CHAPARRAL HEIGHTS-MINOR SUBDIVISION PLAT

LOCATED IN THE SOUTHWEST ONE-QUARTER OF SECTION 28 AND THE NORTHWEST ONE-QUARTER OF SECTION 33,
TOWNSHIP 11 SOUTH, RANGE 63 WEST OF THE 6TH PRINCIPAL MERIDIAN, COUNTY OF EL PASO, STATE OF COLORADO.

PROJECT: 15435 E. CHAPARRAL LOOP
SHEET 2 OF 2
COUNTY: EL PASO, CO
DATE: 12/09/2021

PEYTON RANCHES FILING NO. 1B
A REPLAT OF LOT 62 PEYTON RANCHES
LOCATED IN THE SOUTHWEST ONE-QUARTER OF SECTION 28 AND
THE NORTHWEST ONE-QUARTER OF SECTION 33,
TOWNSHIP 11 SOUTH, RANGE 63 WEST OF THE 6TH PRINCIPAL MERIDIAN
COUNTY OF EL PASO, STATE OF COLORADO.

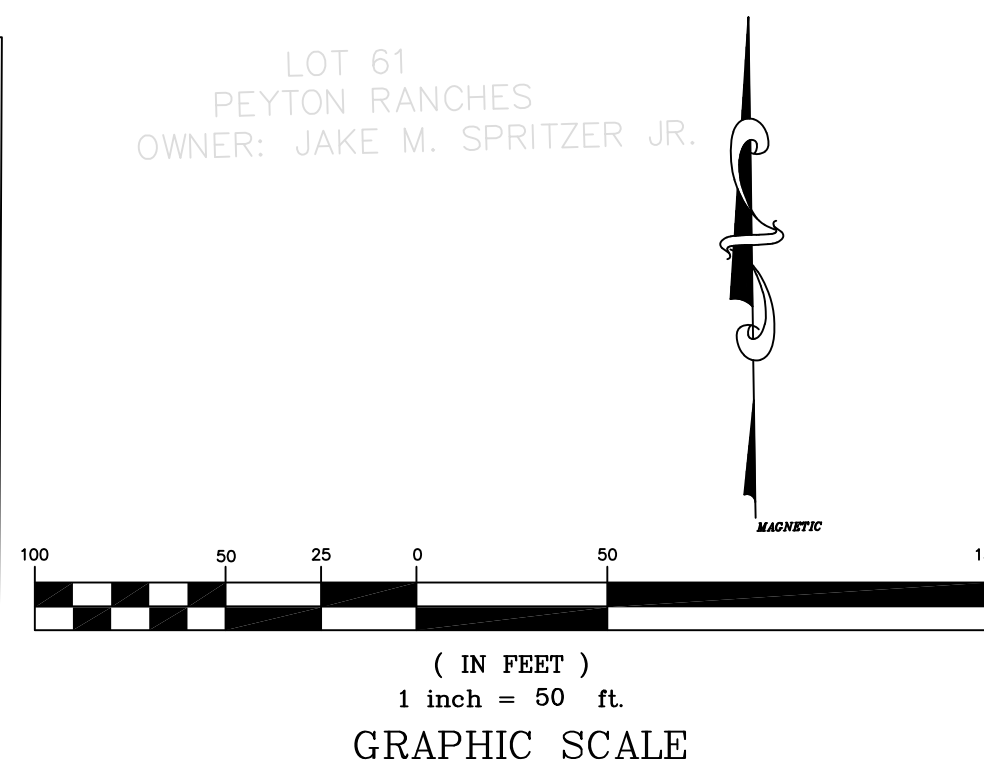
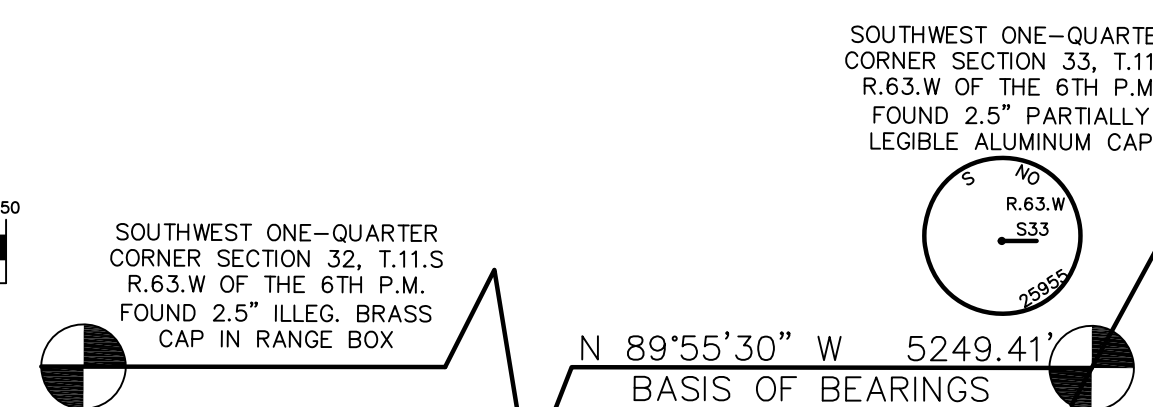
Revise title block to state: "A replat of Lot 62, Peyton Ranches." Remove "minor subdivision plat."

Missing front easements. May be beneficial to state that the front and rear of the lots are also the subdivision boundary.

The name of the subdivision shall be "Peyton Ranches Filing No. 1B" since this is a replat of Peyton Ranches.

Include a reception number for the access maintenance agreement.

Remove approval block - PCD Director signature line should be placed below BOCC signature line.

Add a scale to this map or write "not to scale"

Please add PCD File No. VR 225

Lots will be
named 62A,
62B, and
62C.
